TRAILS AT ASPEN RIDGE FILING NO. 5

FINAL GRADING & EROSION CONTROL PLANS

OCTOBER 2021

PCD FILING NO.: SF-21-038

TRAILS AT ASPEN RIDGE- F5			
GRADING AND EROSION CONTROL PLAN			
LEGEND & ABBREVIATION NOTES			
DESIGNED BY: CRD	SCALE: N.A.	DATE ISSUED: OCTOBER 2021	DRAWING No. GEN01
DRAWN BY: CRD	HORIZ: N.A.	SHEET 3 OF 7	
CHECKED BY: NMS	VERT: N.A.

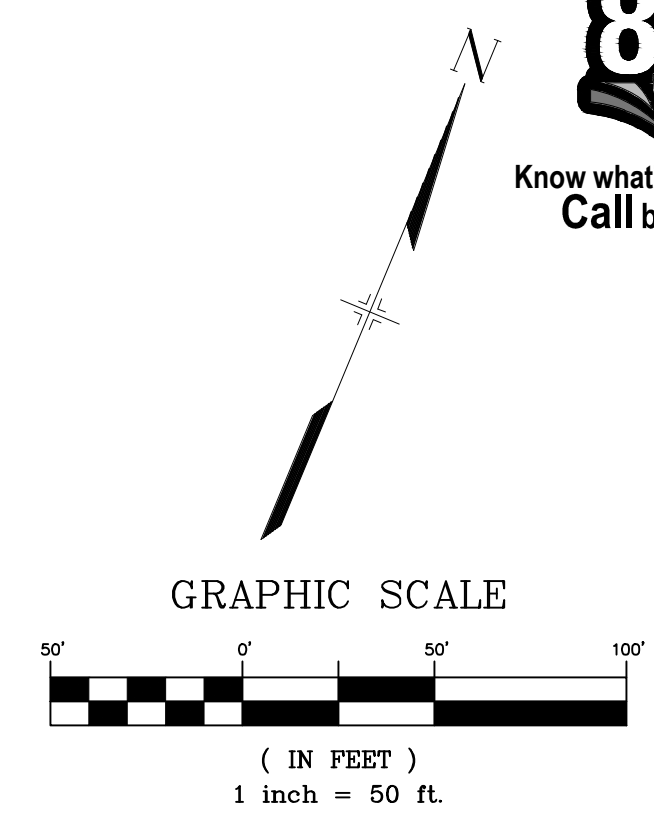
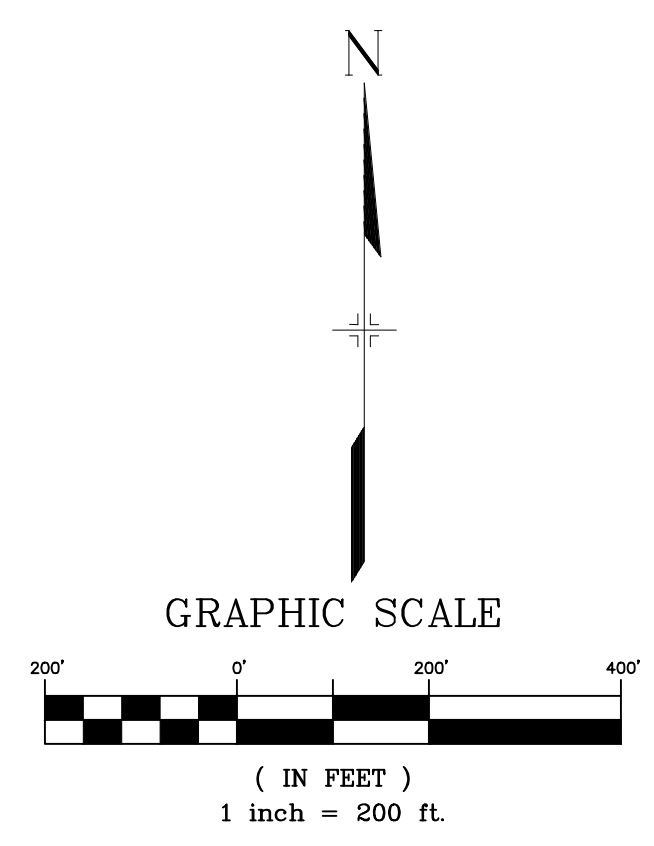
My previous comment with Review #1 on the Legend was to show the Cut/Fill line on the plans. No the Cut/Fill line is no longer on the Legend and still not on the plans. Per Checklist Item "P" cut/fill areas need to be identified.
